Application No: AB/54/20/PL
Site Address: 6 The Old Slipway River Road Arundel BN18 9EY
Description of works: New second floor Juliet balcony. This application may affect the character & appearance of the Arundel Conservation Area.

Thank you for your internet representation made on 29th June 2020 which has been recorded as no objection with the comments as follows:

Second Floor Plan + Elevations
as Proposed

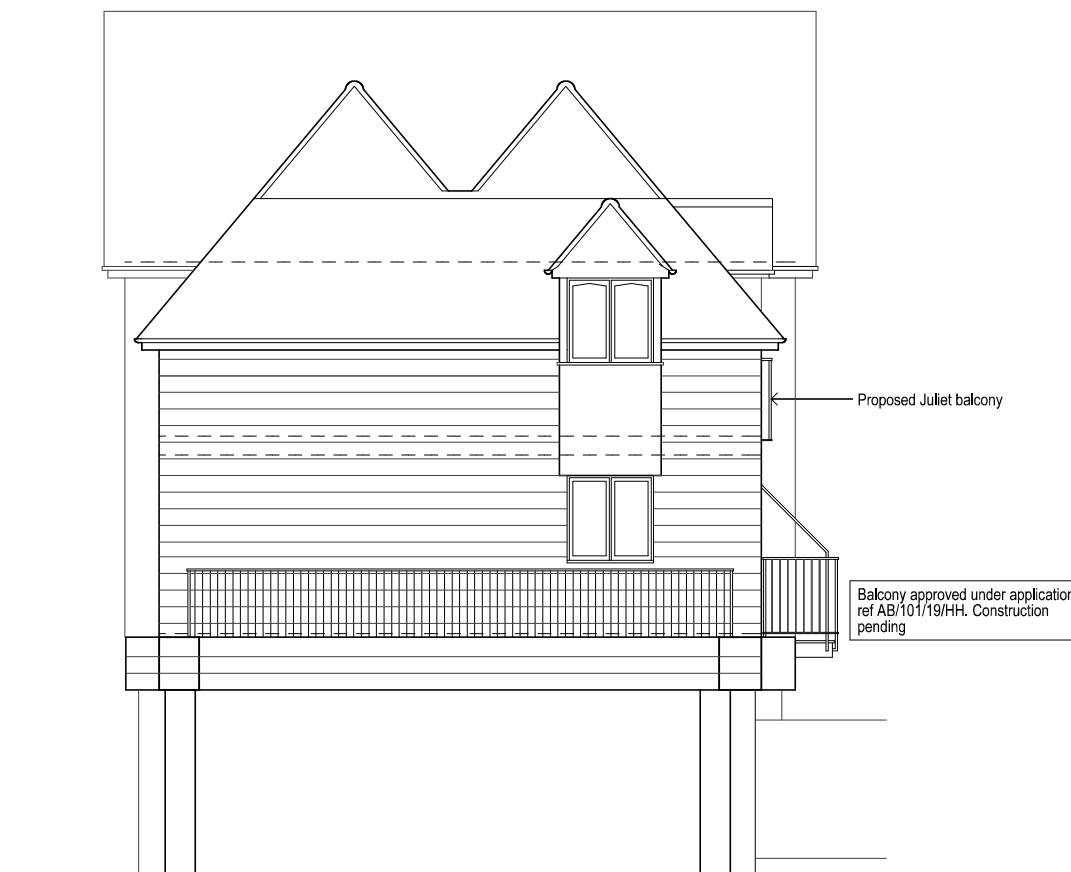
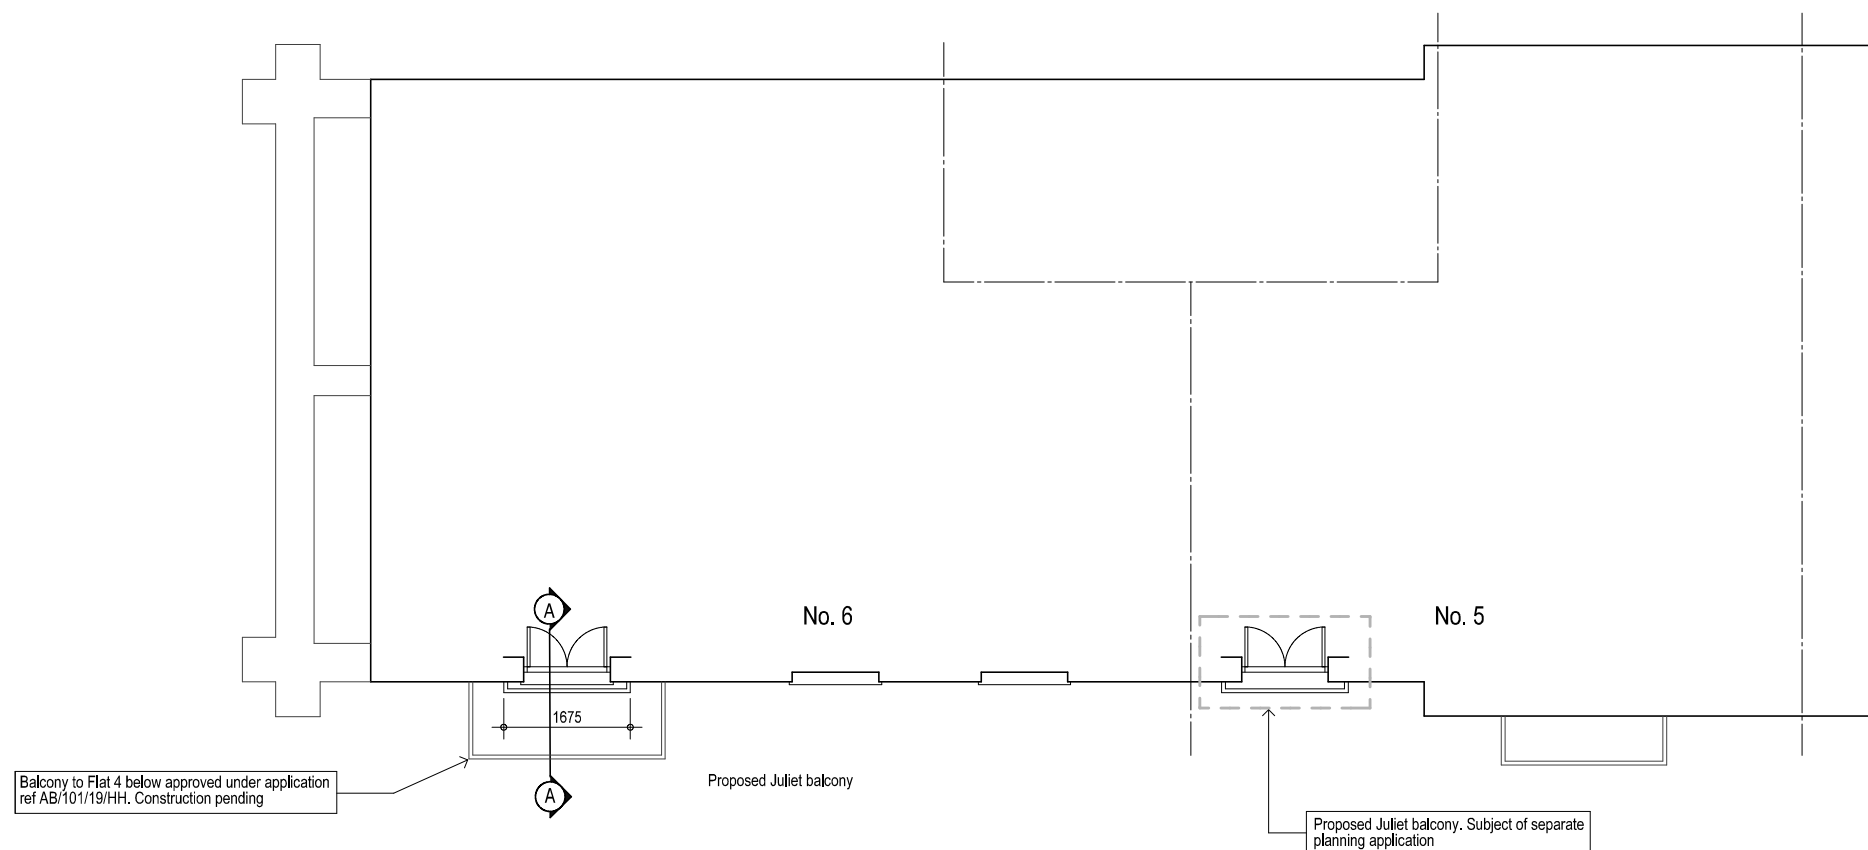
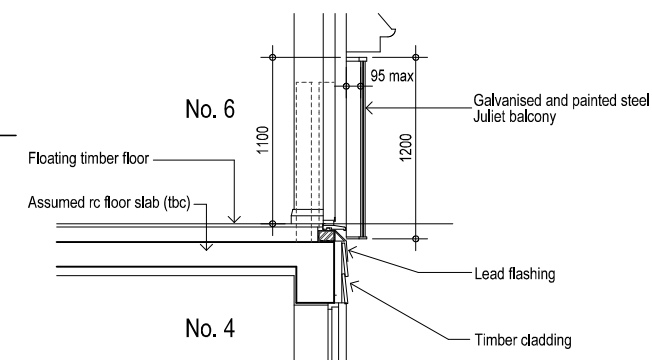
The scale, materials, proportions and sizes of these proposed balconies are sympathetic with those of the host building. The installation of these appropriately sized and proportioned structures provides visual interest on the river elevation.

It is suggested that a condition be attached to any planning permission requiring details of the colour of the paintwork for the balconies since it will be important to ensure a consistent colour scheme for all these new structures on the river elevation of the building. The new french doors also need to match existing ones in external appearance, including colour.
